CITY OF ALBUQUERQUE

September 2, 2010

Re: Office/Warehouse, 5454 Pasadena NE, Conceptual Grading and Drainage Plan

Engineer's Stamp dated - no stamp- (B18/D018)

**CONCEPTUAL
DRAINAGE AND
GRADING PLAN**

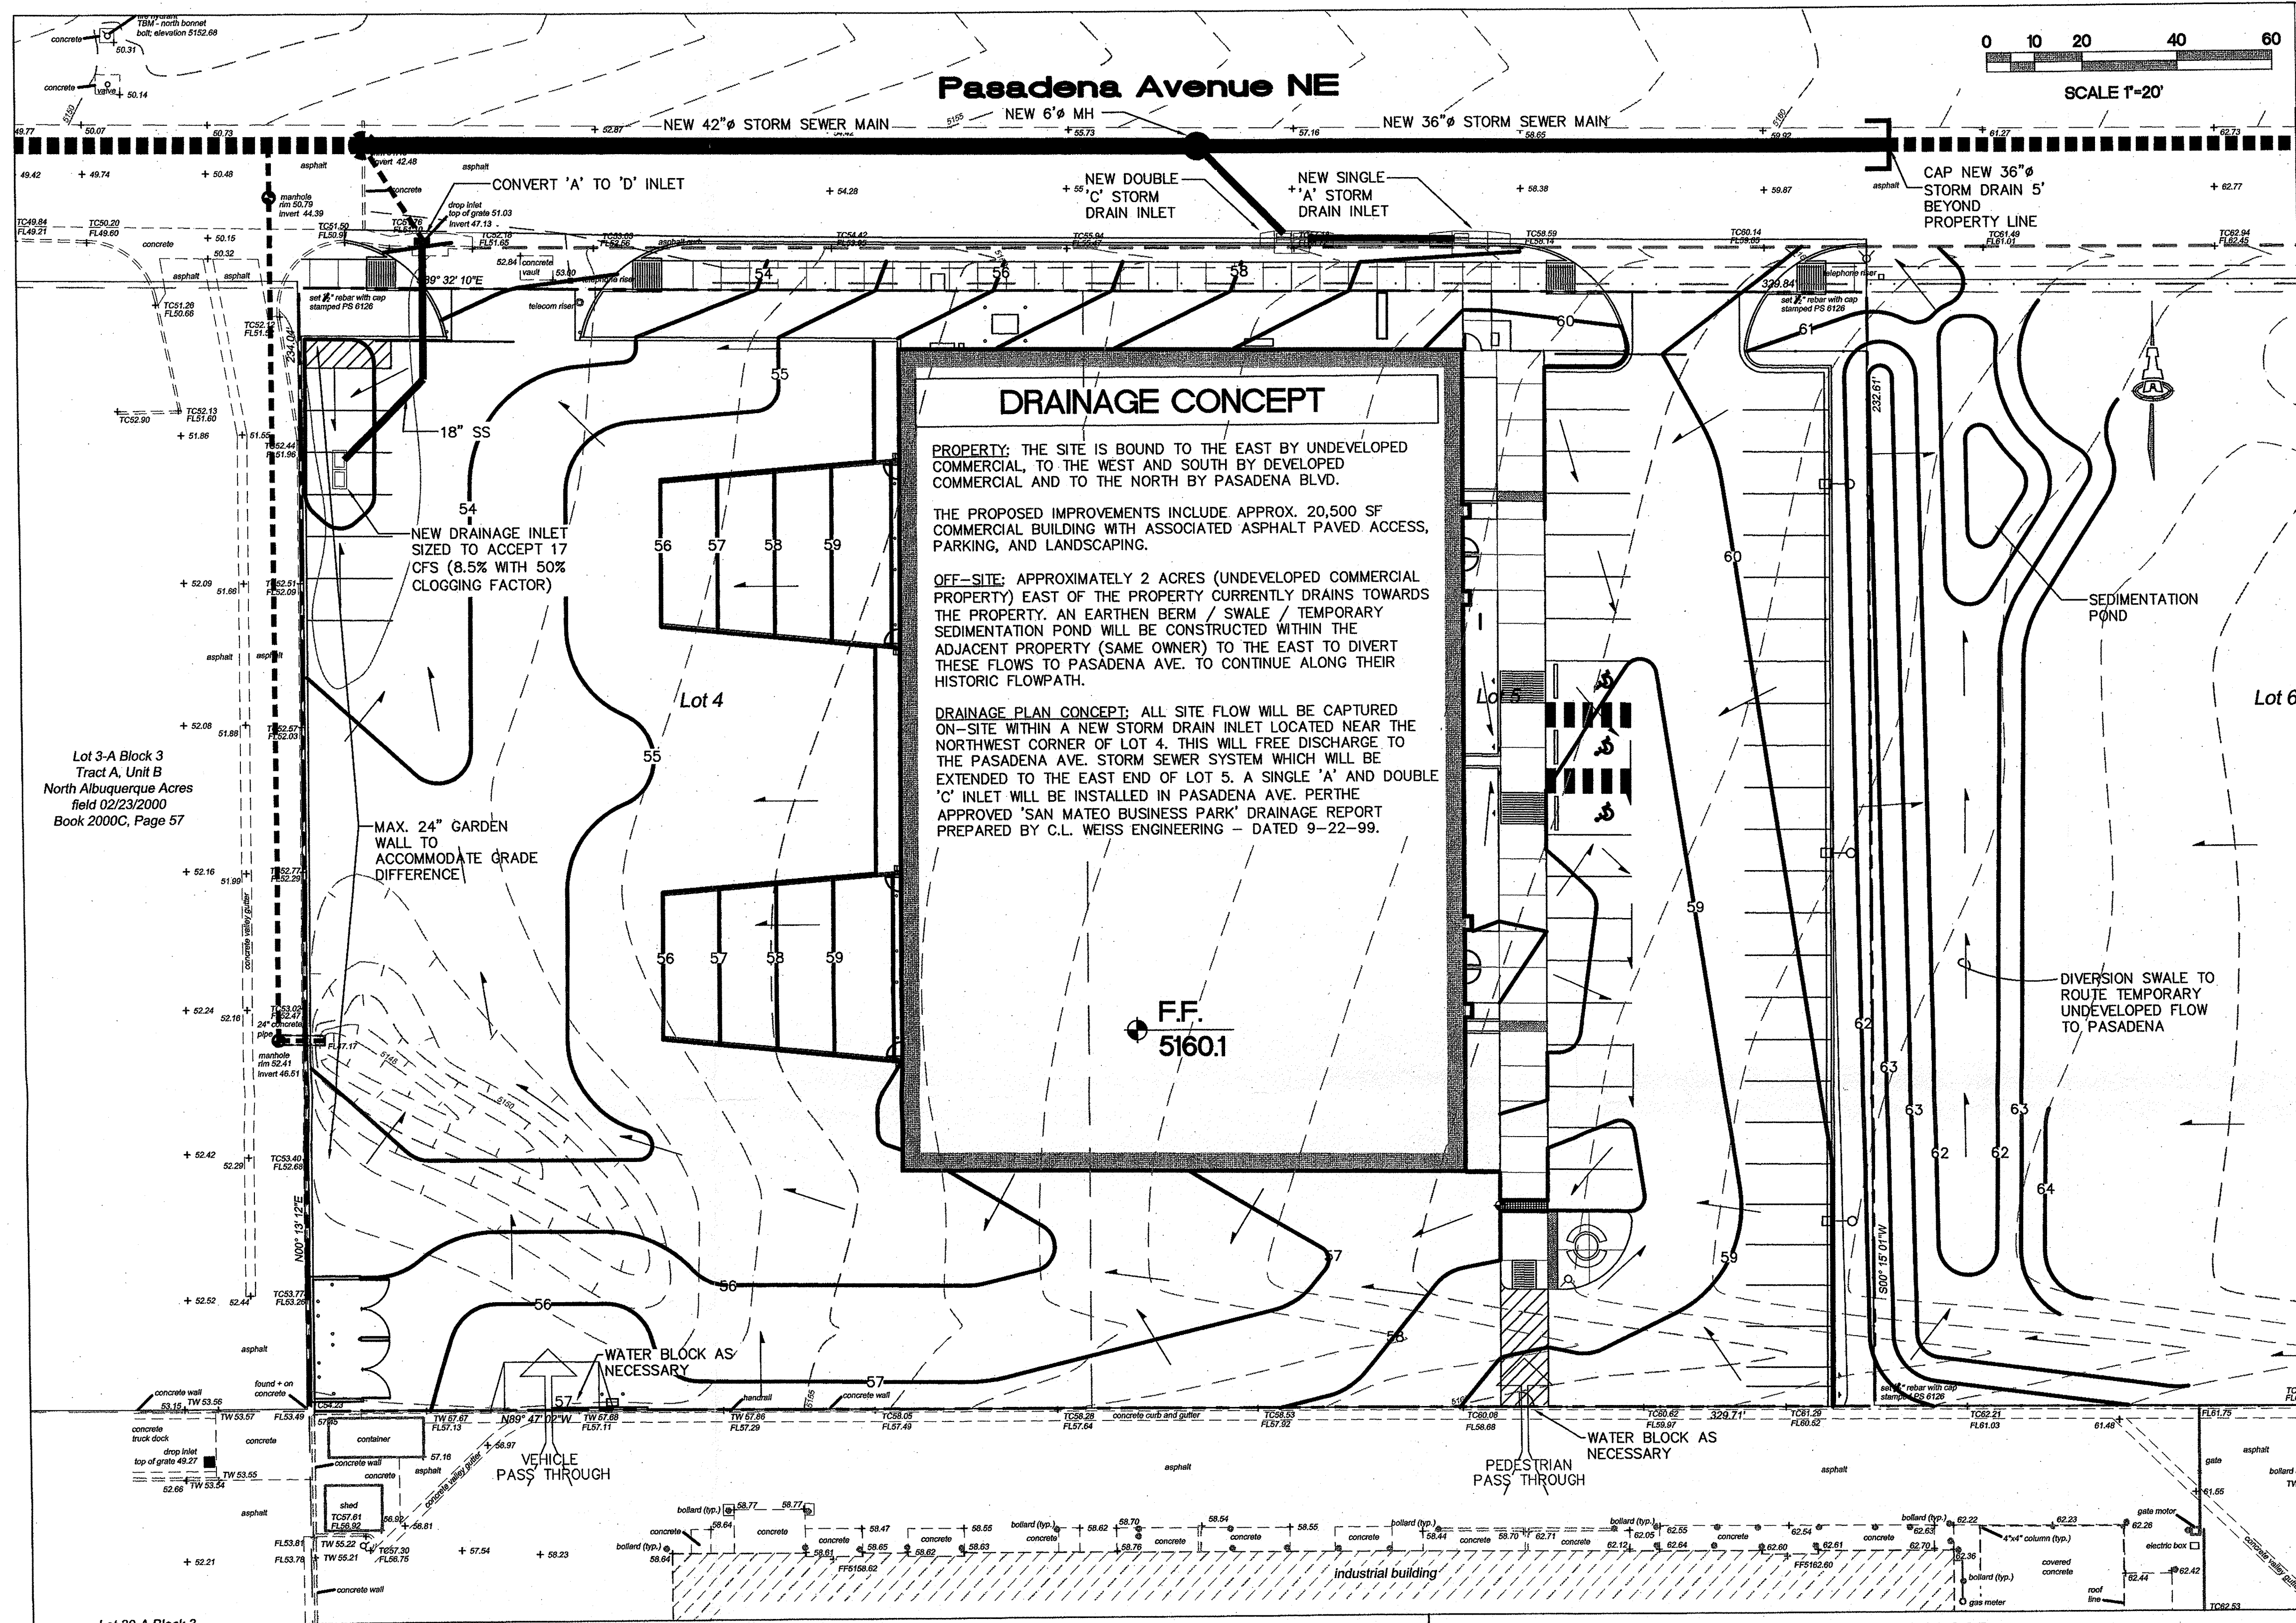
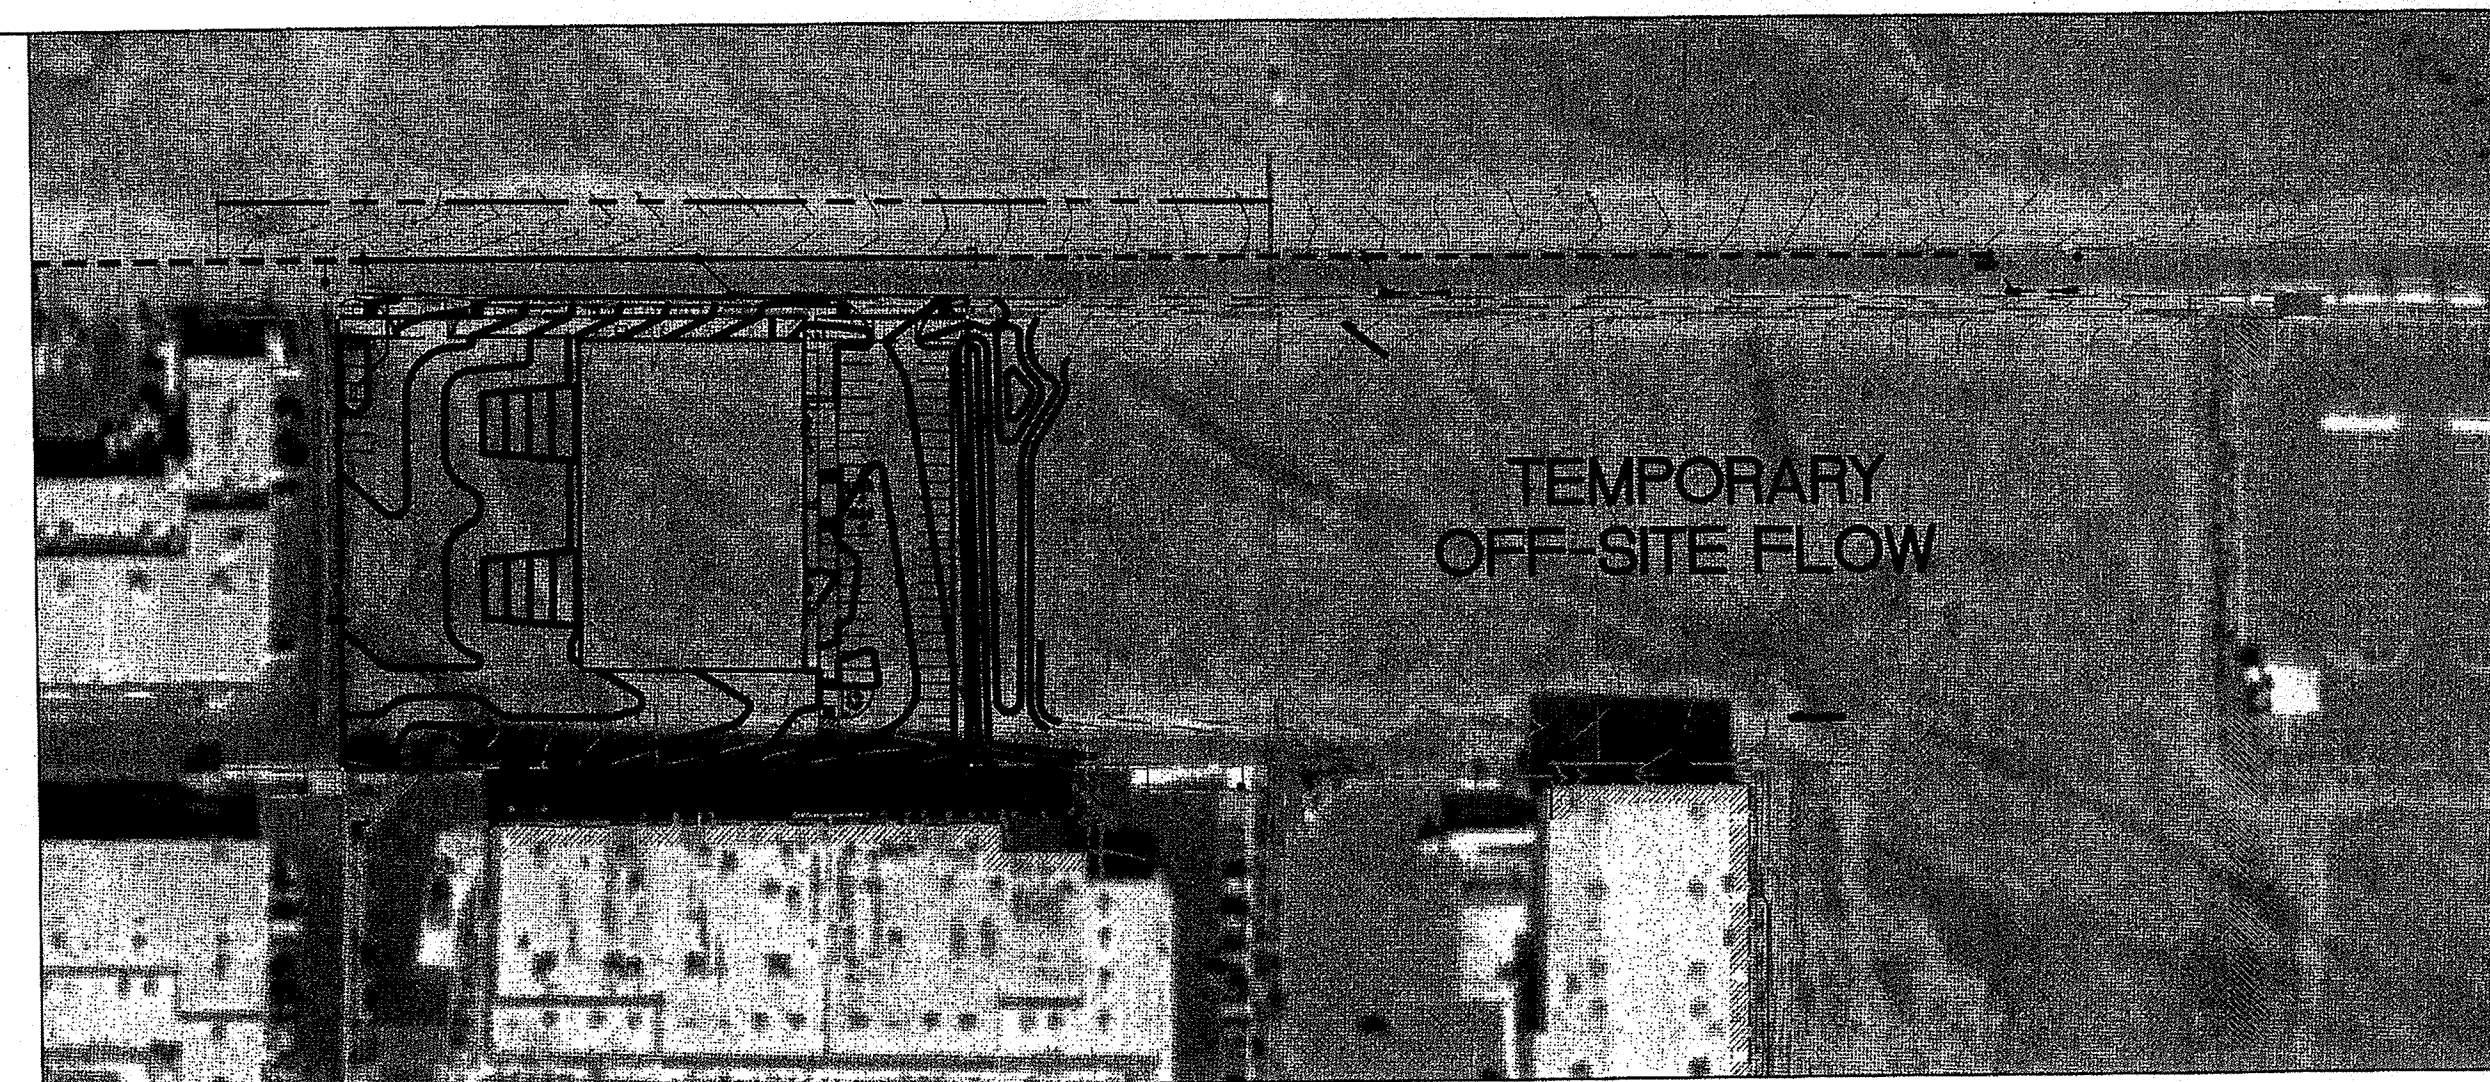
- Provide existing contours.
- The storm drain in Pasadena is required to be extended to the east property line of this site. This plan should show the proposed storm drain along this property's frontage in Pasadena Ave or mention it in the narrative.
- There is an existing private storm drain on site that should be used to minimize the flow entering Pasadena Ave.
- A sedimentation pond should be built with the diversion swale near the north property line.
- The plan should be stamped and signed, even though it is not for construction.
